Subject: RE: AL/49/21/DOC - Springfield, Hook Lane

Thank you both for your recent emails in connection with the recently submitted Arboricultural Report from EcoUrban Ltd.

Title:-
Proposed Hedgerow Protection Plan

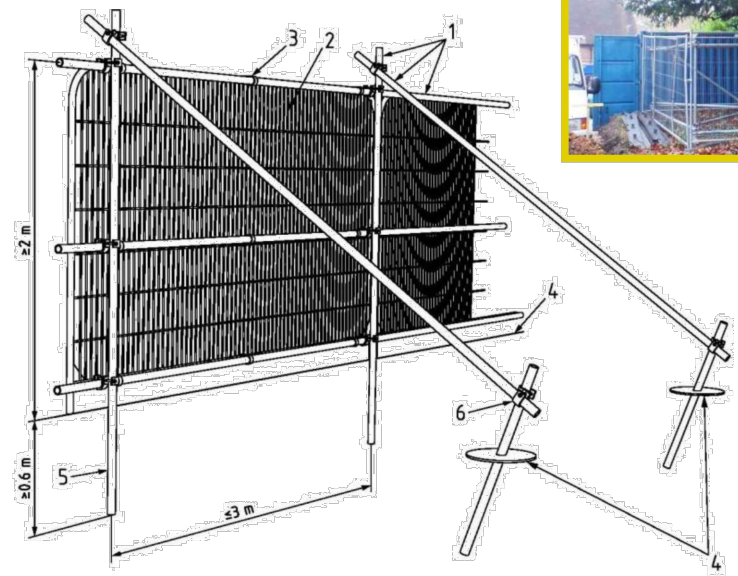
It is clear from the EcoUrban report that work to install the protective fencing was ongoing and incomplete. Condition 4 is clear – ***all protective fencing and ground protection measures will be inspected to verify they are 'Fit for Purpose' as required under British Standard 5837:2012 and have been erected and positioned exactly as shown on the "Tree Retention and Protection Plan", dwg.no. LLD1680-ARB-DWG-002, Rev 08.*** Prior to commencement.

I offered a relaxation of the requirement for default specification fencing (BS5837:2012, figure 2) but only along the S boundary, not the N or E boundaries.

You will need to satisfactorily address all the outcomes stated in my email of 7th June, before I can support an approval of this application. To include once again - clear photographic evidence of the necessary refinements and brief written report confirming the same, from the project arboriculturist.
